Re: Existing Tank Application # 07-5-19042

Based on the criteria set out in Title 15A, Subchapter 18A, of the North Carolina Administrative Code, Rules .1950, the evaluation indicated that the site is **UNSUITABLE** for the addition requested. Therefore, your request for an existing tank is **DENIED**. The site is denied based on the following:

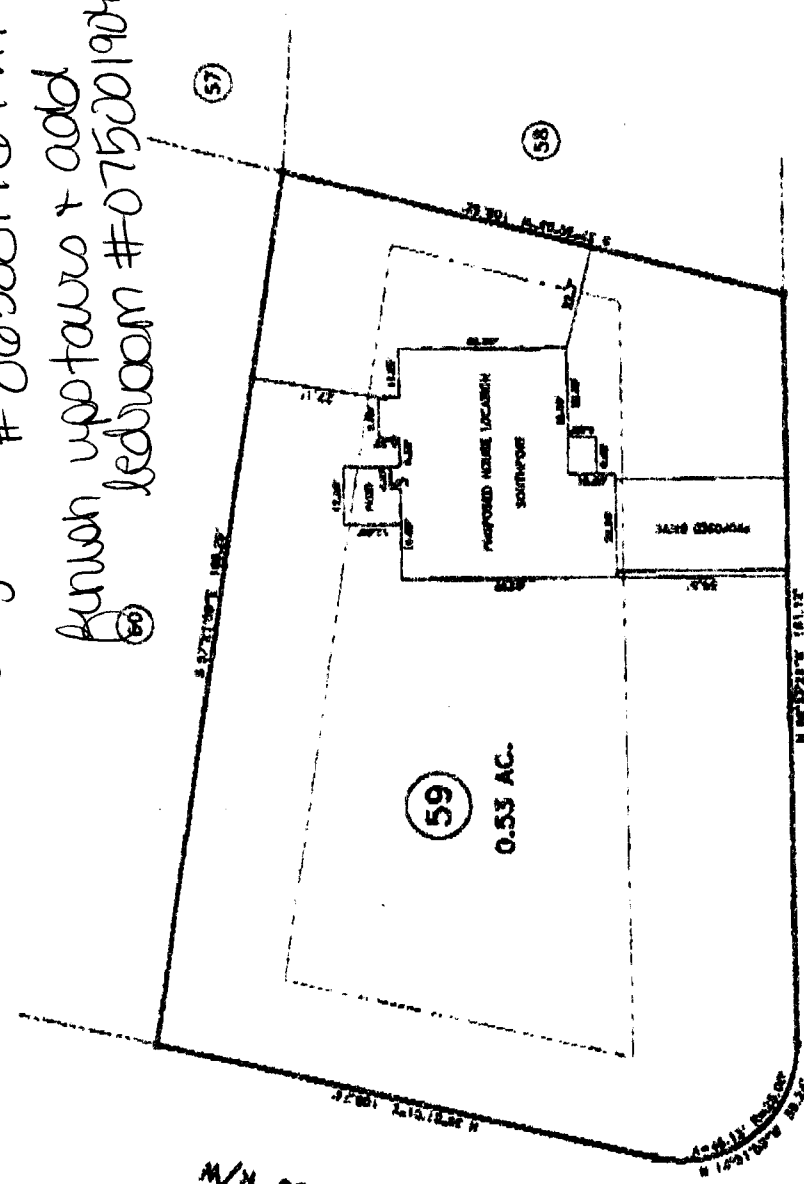
- 15A NCAC 18A.1950 a(16) Any swimming pool must be 15' from any part of septic system.
- 15A NCAC 18.1945 (b) Each lot shall have original septic system plus repair area. (Lot was permitted for 3 bedrooms)
- 15A NCAC 18A.1950 (10) – Any building to be 5' from drain line.

- #1 - Fill out soil evaluation application at Central Permitting to see if there is enough space to add line and repair for 4th bedroom.
- #2 - Add the room without a closet and not use as a bedroom.
